About the application

Application number: 2026/91657	
What is the application for?:	Variation of condition 2 (plans) on previous permission 2020/93954 for erection
Address of the site or building:	Land at Lingards Road, Slaithwaite, Huddersfield, HD7 5HY
Postcode:

Rev B	03/06/2026	Updated for planning submission.		
Rev A	24/09/2025	Minor amendments, dimensions added.		
Project :		Housing at Lingards Road, Slaithwaite.		
Client :		SB Homes.		
Drawing :		Plot 23 - OPTION 1.		
Scale :		1:100.	Date :	May 2025
Dwg No :		2019 572 Sk 15	Rev :	B

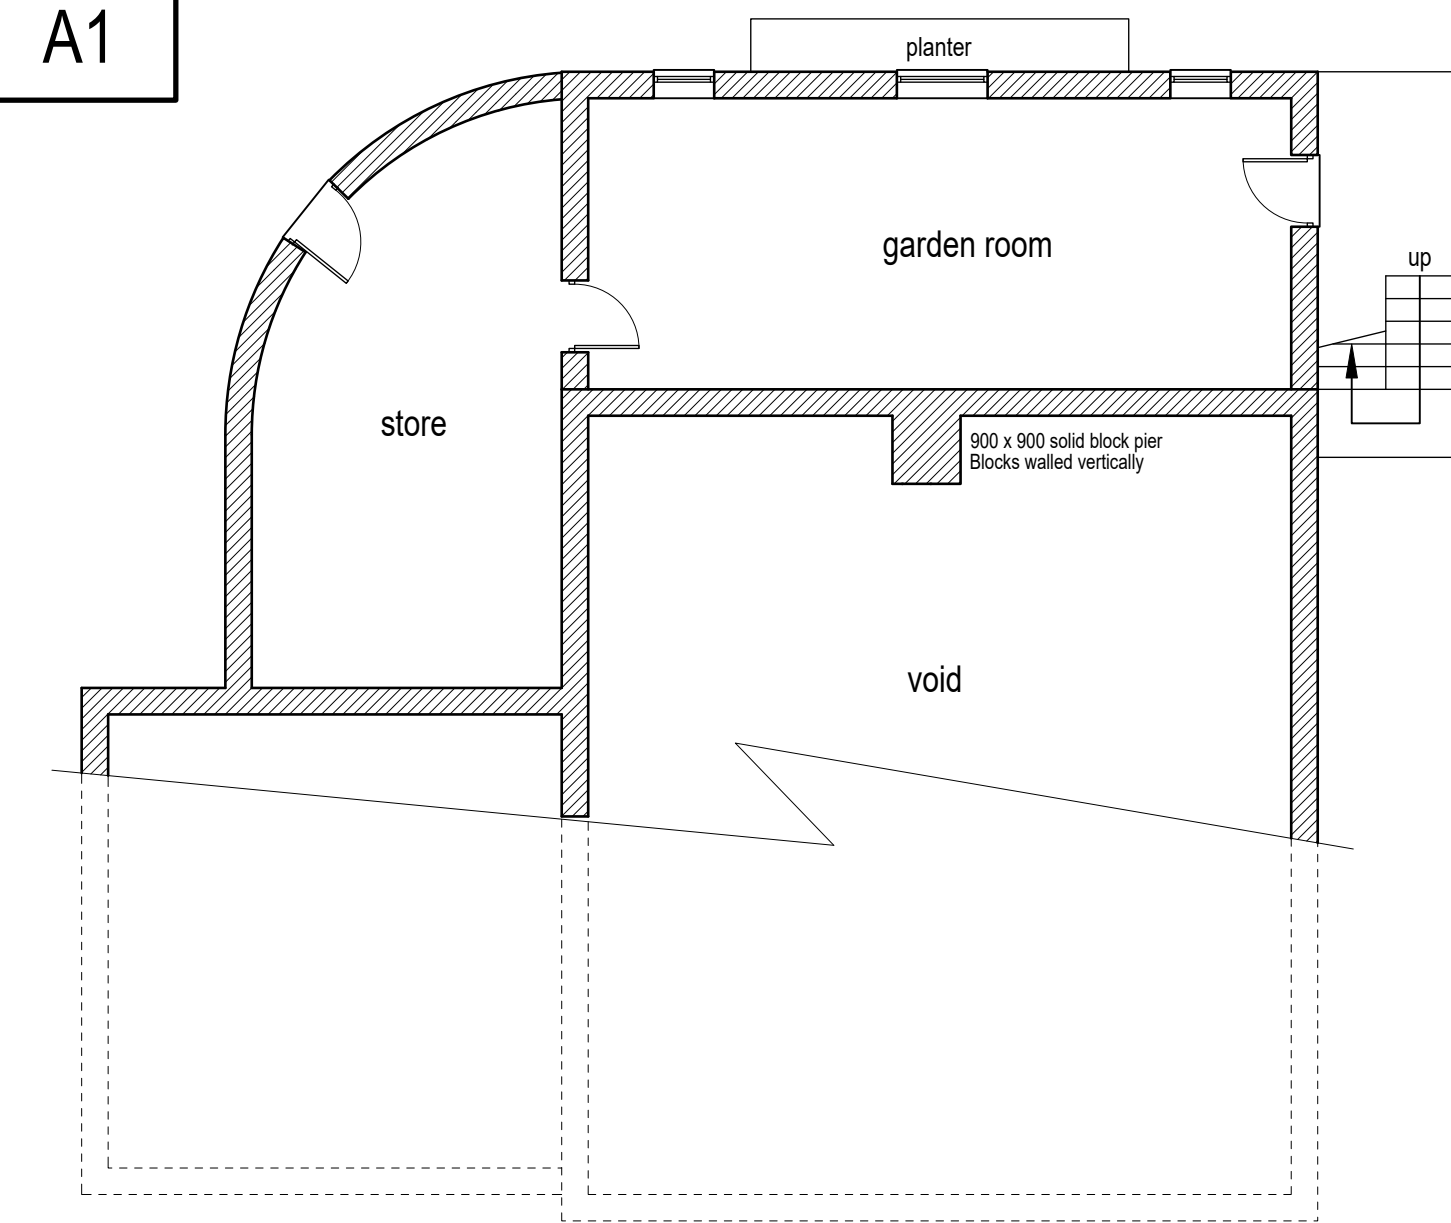
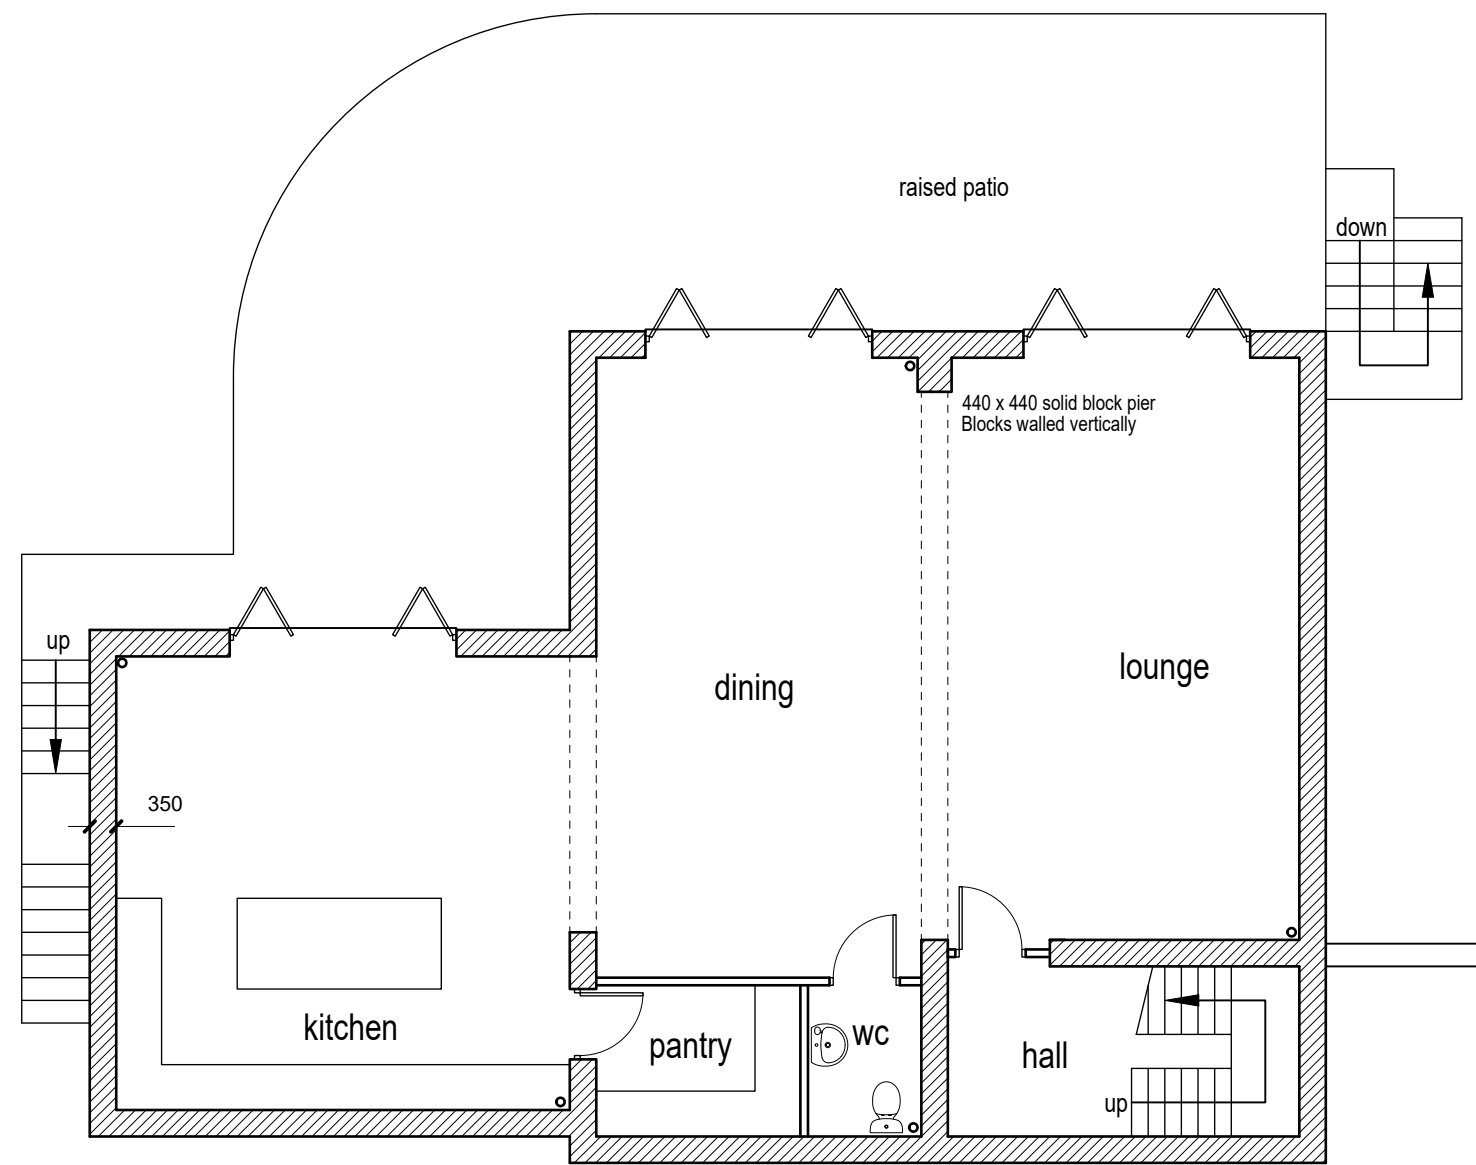
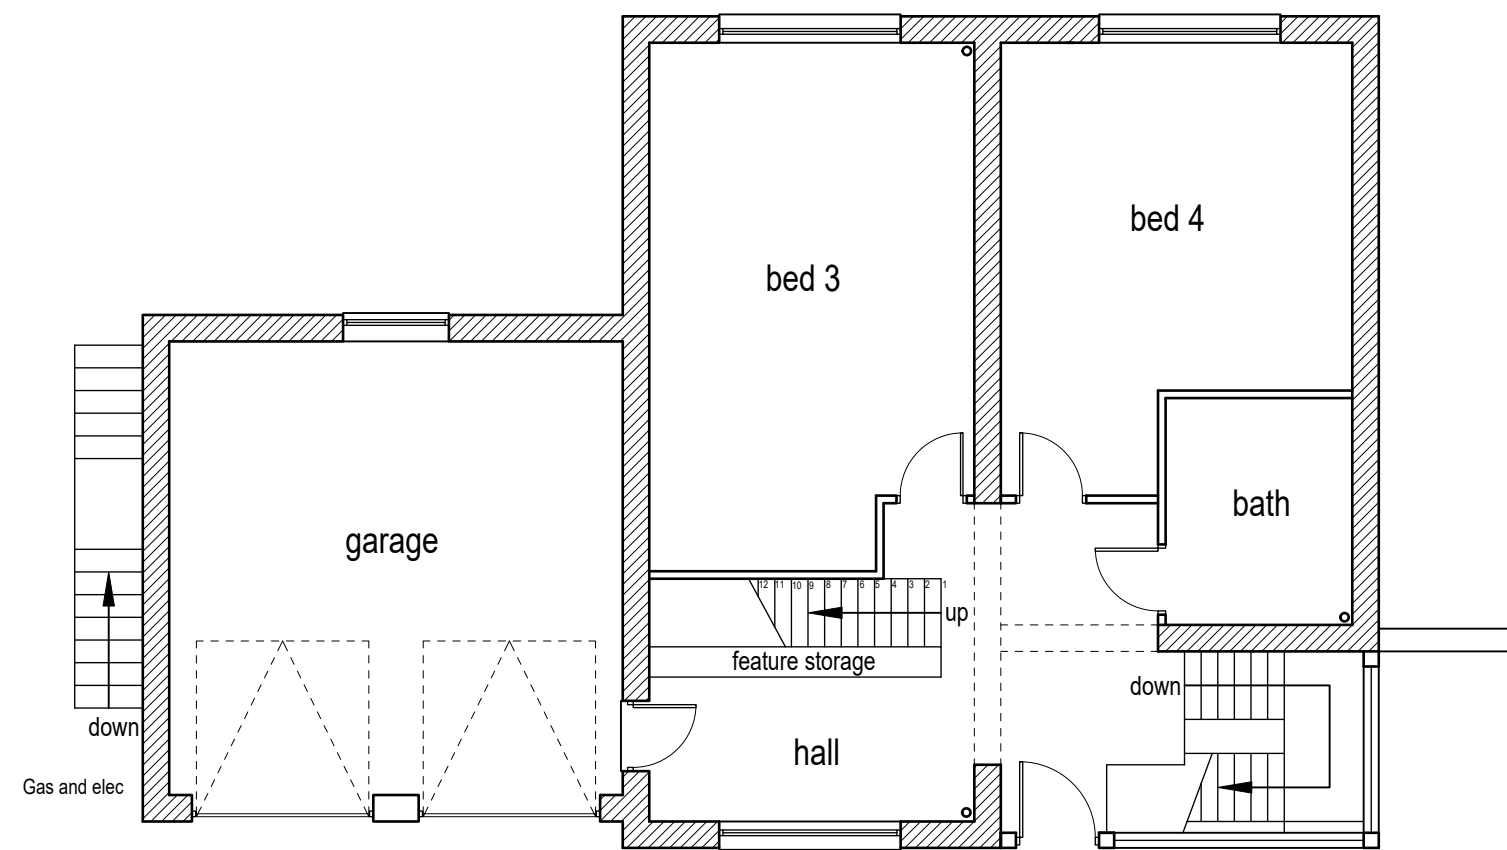
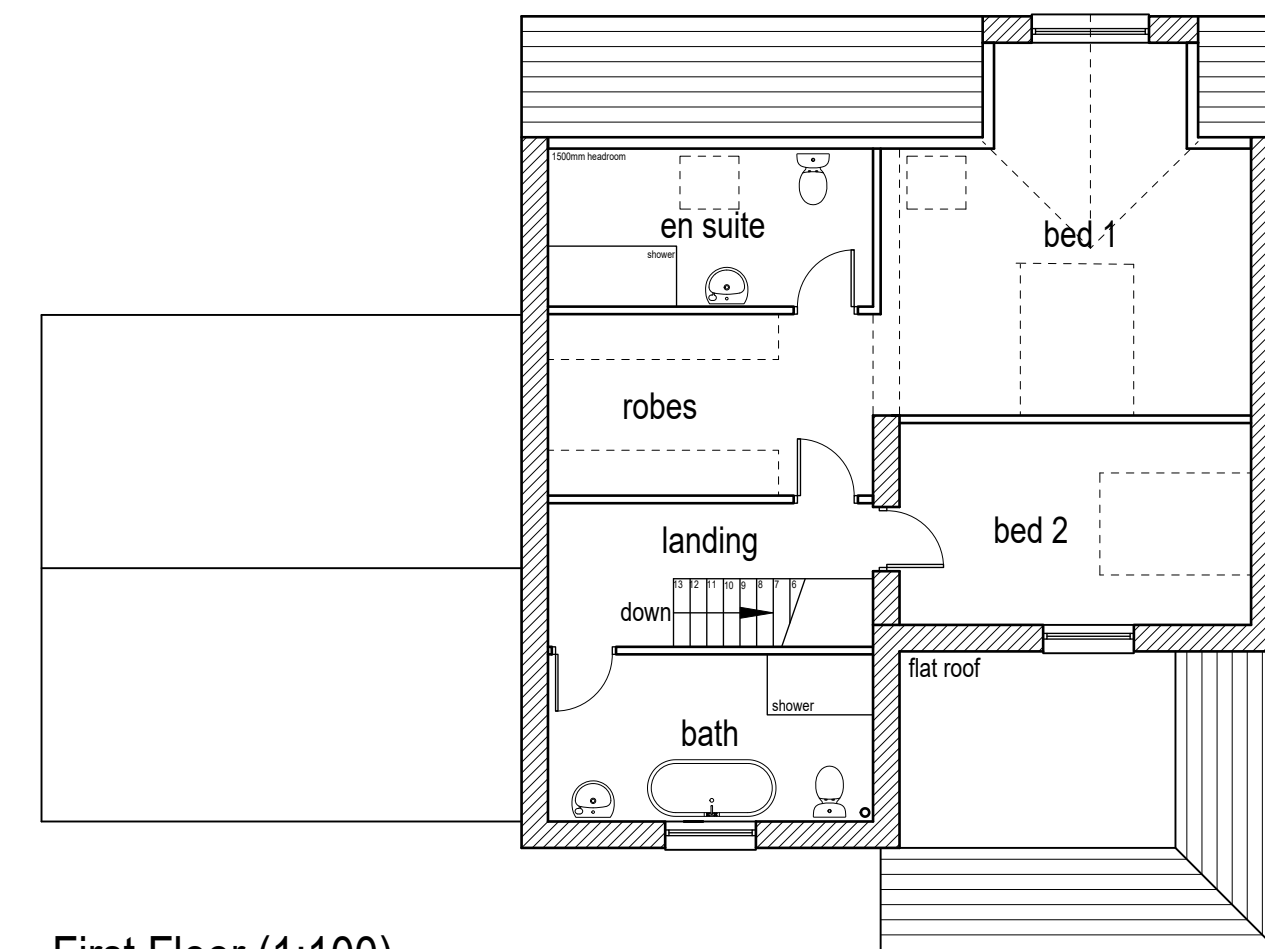
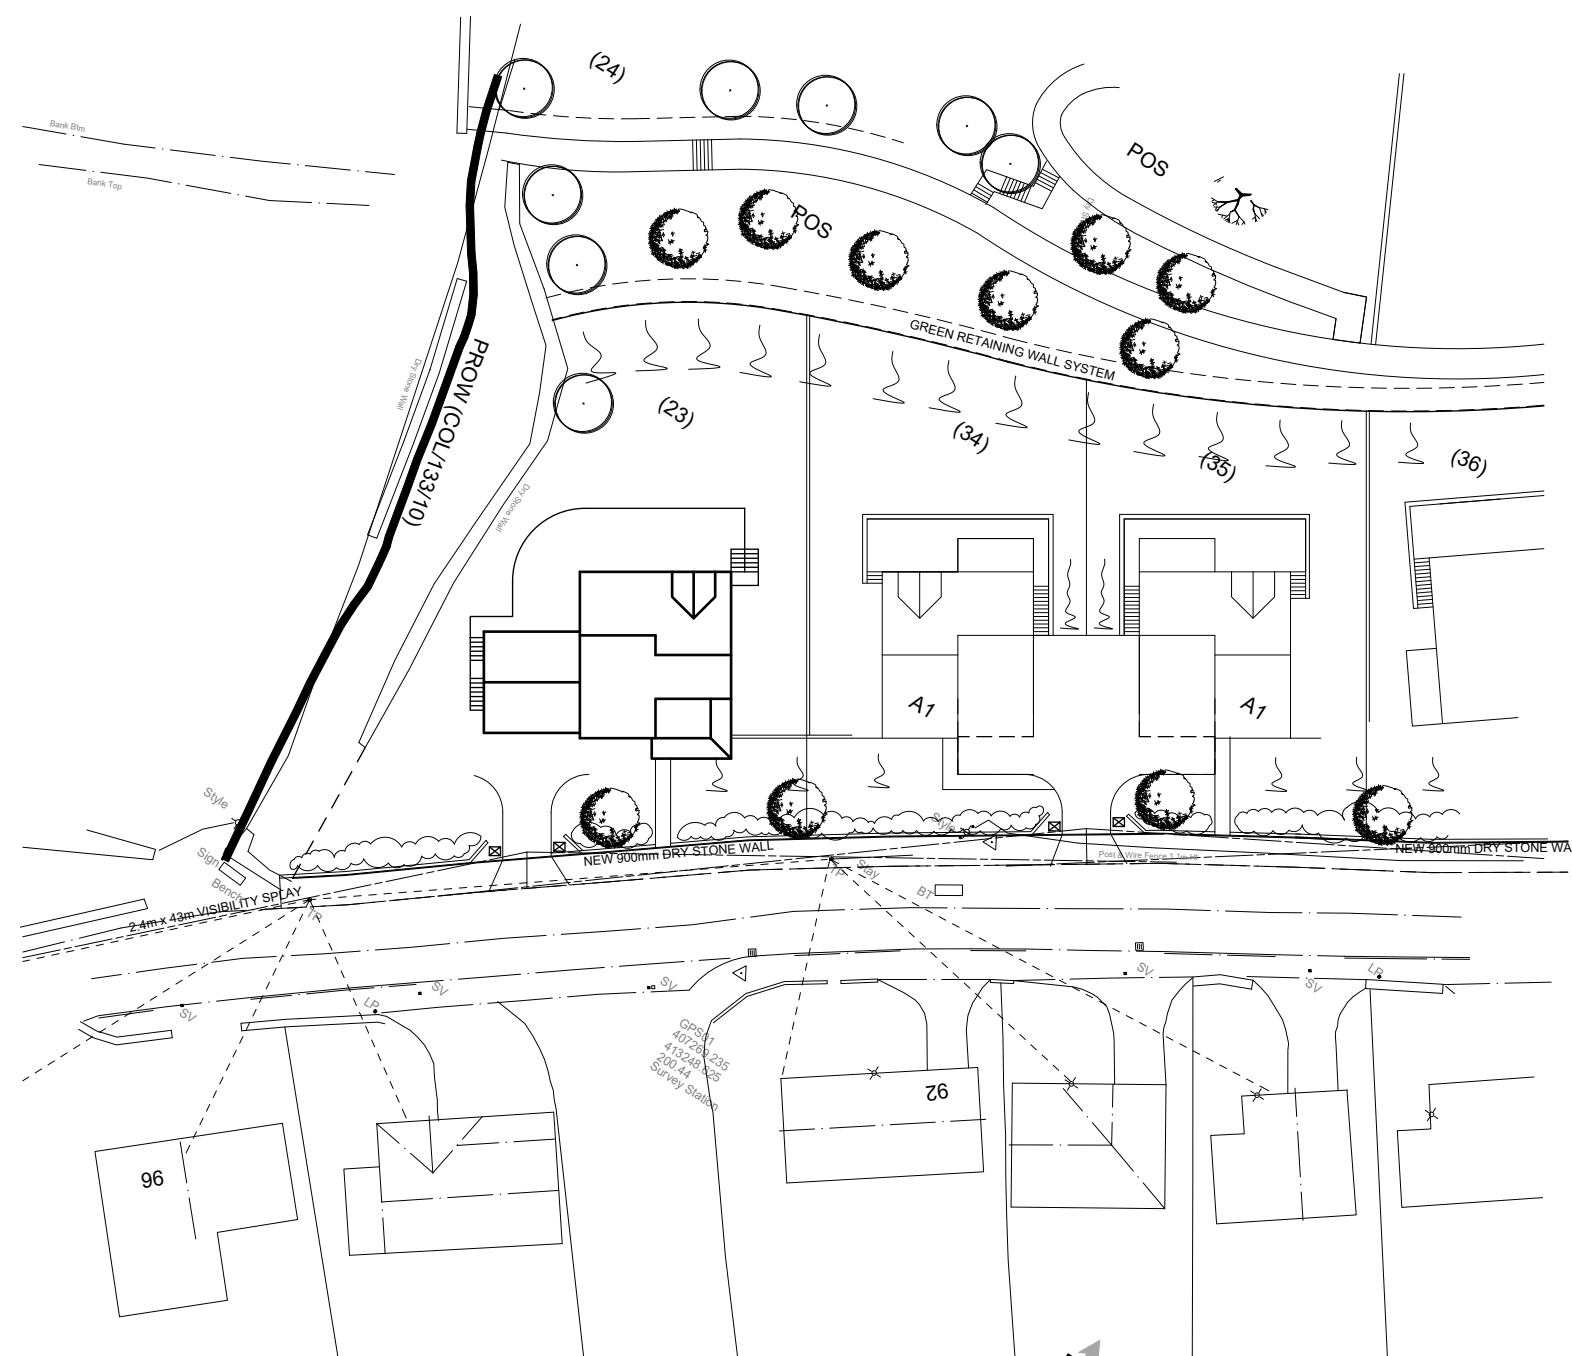
Type of comment: An objection	
Do you wish your comments to be published on the website anonymously?	Yes
This variation by the developer could and should of been submitted on the original application, thew developer has all ready built the foundations on the assumption that the variation will be approved and is avoiding the scrutiny of a full application and the design intent that was stated by the developer at the time application was approved.
